ENG-PUDSP22001-R1-CDs-Storm.pdf Markup Summary

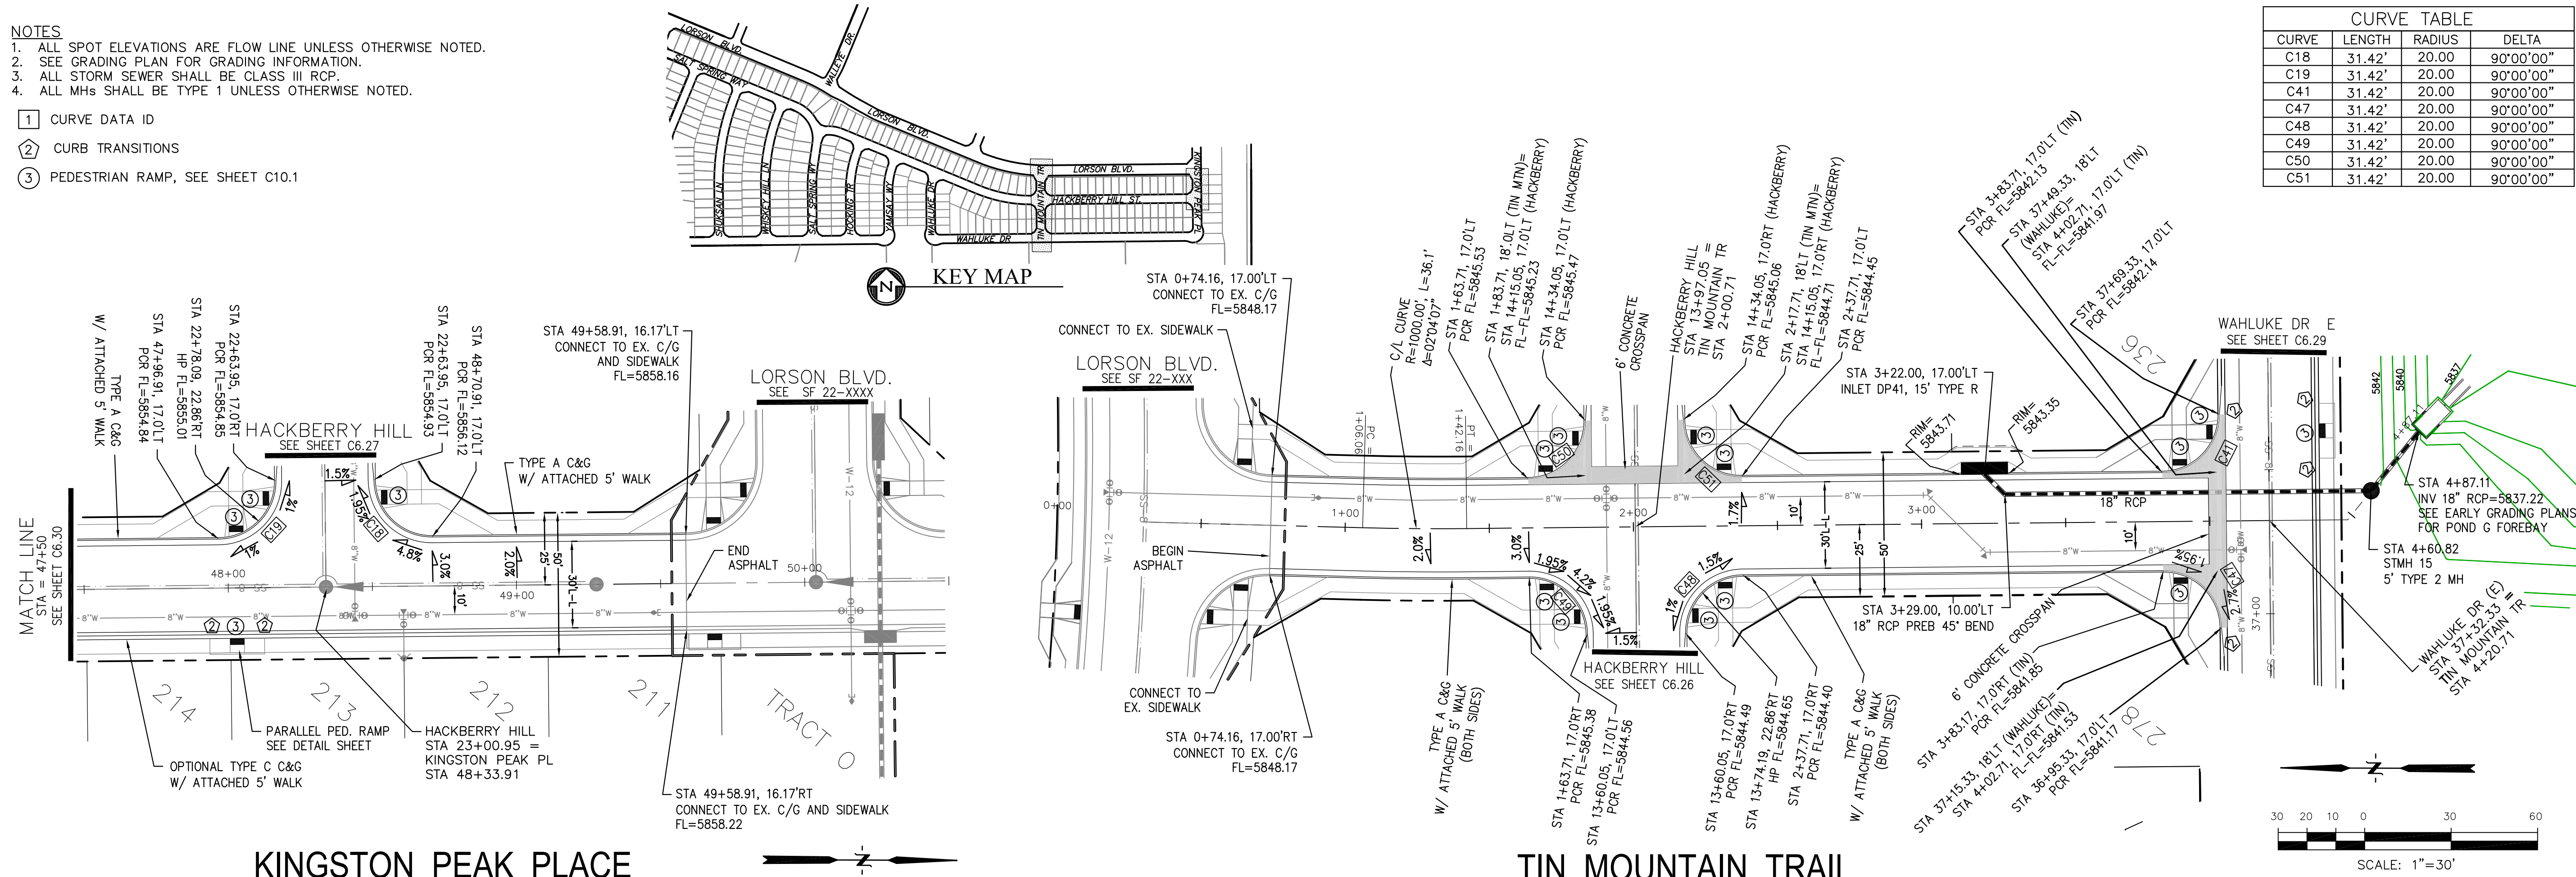
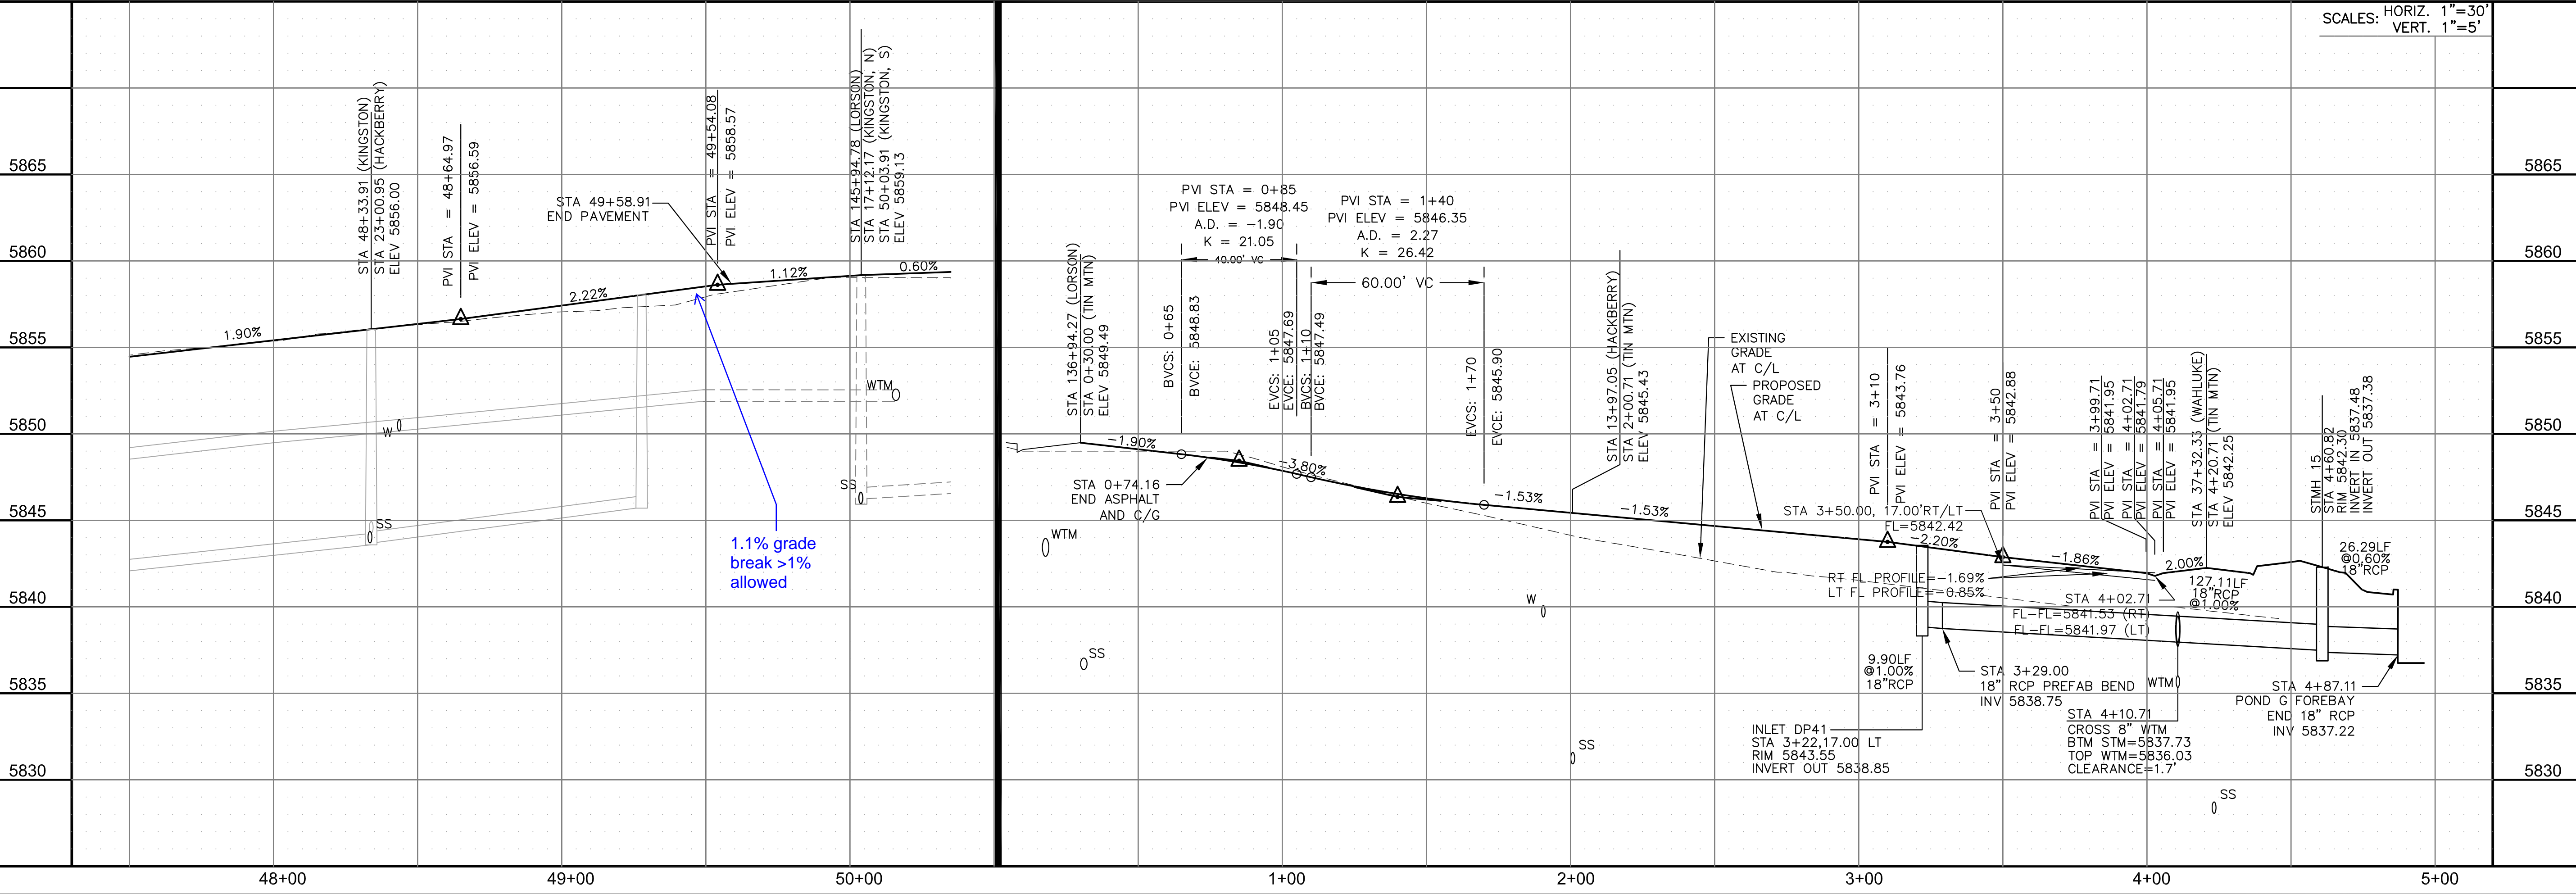
Ped ramp?
